CONSULTEE RESPONSE (Council's Arboriculturist)

Reference: Y/67/22/HH

Proposal: Erection of detached workshop, gym/hobby and greenhouse. This application affects character and appearance of the Main Road/Church Road Yapton Conservation Area and the setting of a Listed Building

Location: Berri Court, Main Road, Yapton, BN18 0ED

Title
SITE PLANS

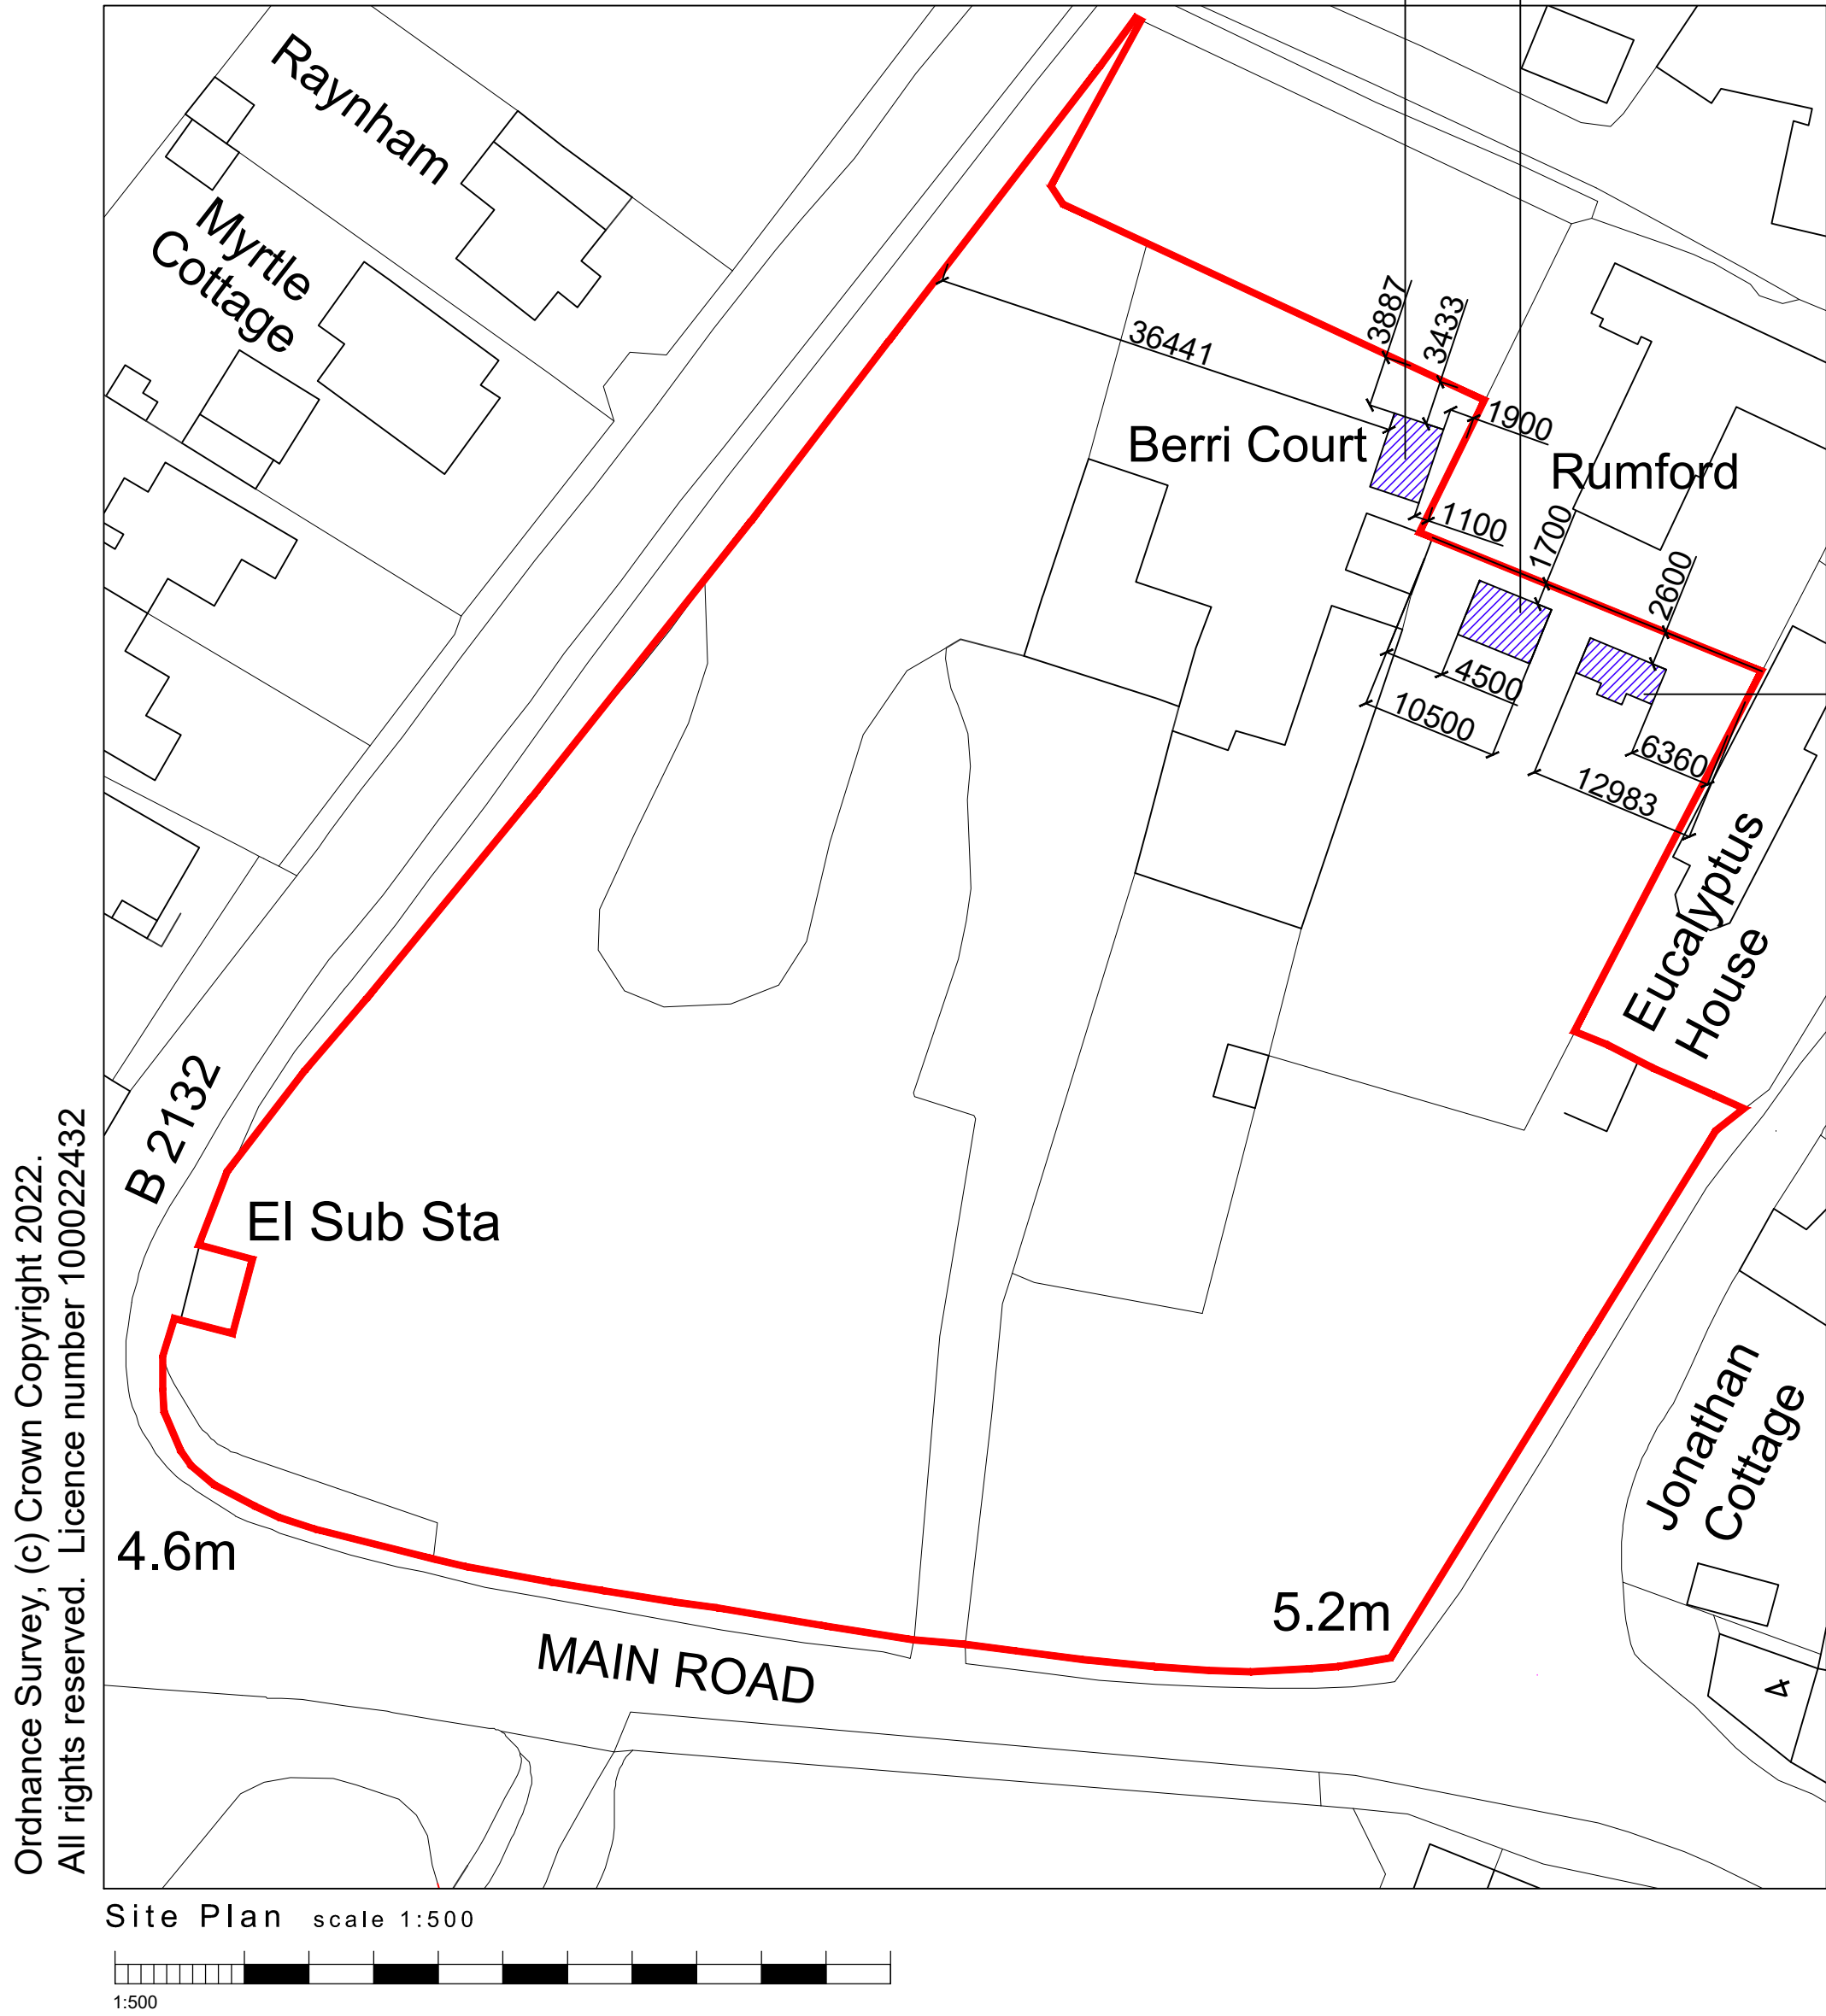
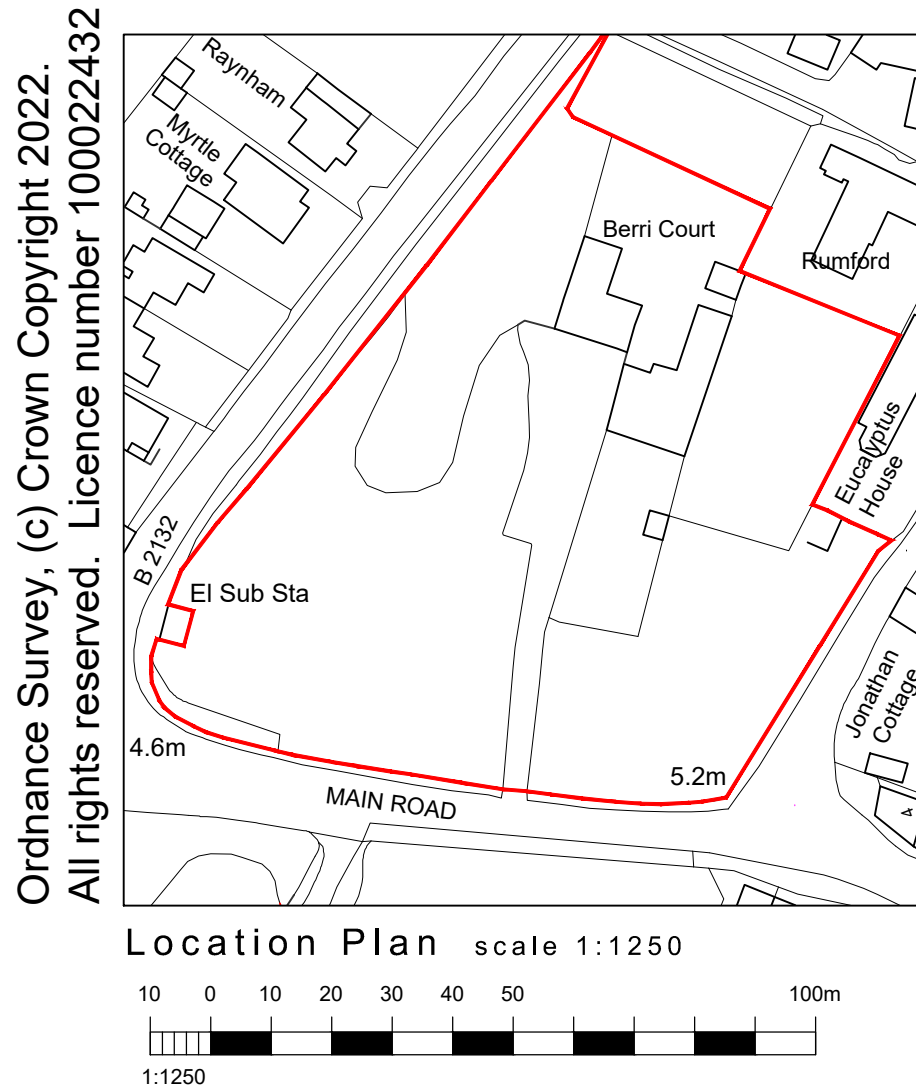
No Arboricultural Method Statement or Tree Protection Plan has been submitted for this project, despite construction work proposed within the root protection area (RPA) of retained trees.

It is accepted that T2 is in decline with low potential to recover and as such ought not to be a significant constraint on any development proposal. That said, it is proposed for retention, therefore, to be adequately considered and protected.

- Type and position of fencing to discourage construction overspill into RPA of T1.
- Ground protection over RPA of T2 to prevent contamination/compaction of soil during construction/installation of gym/hobby room.
- Construction management plan to show relative positions of material/plant storage and welfare facilities.
- Method of ground levelling-up within RPA of T2 prior to pouring concrete slab for foundation of gym/hobby room.
- Confirmation of any facilitation pruning to aid installation/maintenance of structures.
- Confirmation of routes and methodology for installation of any subterranean utility apparatus within RPAs.

The applicant must submit an Arboricultural Method Statement (AMS) and Tree Protection Plan (TPP) to the local planning authority for approval. Written confirmation of acceptance of both AMS and TPP must be issued before any works are commenced on site.
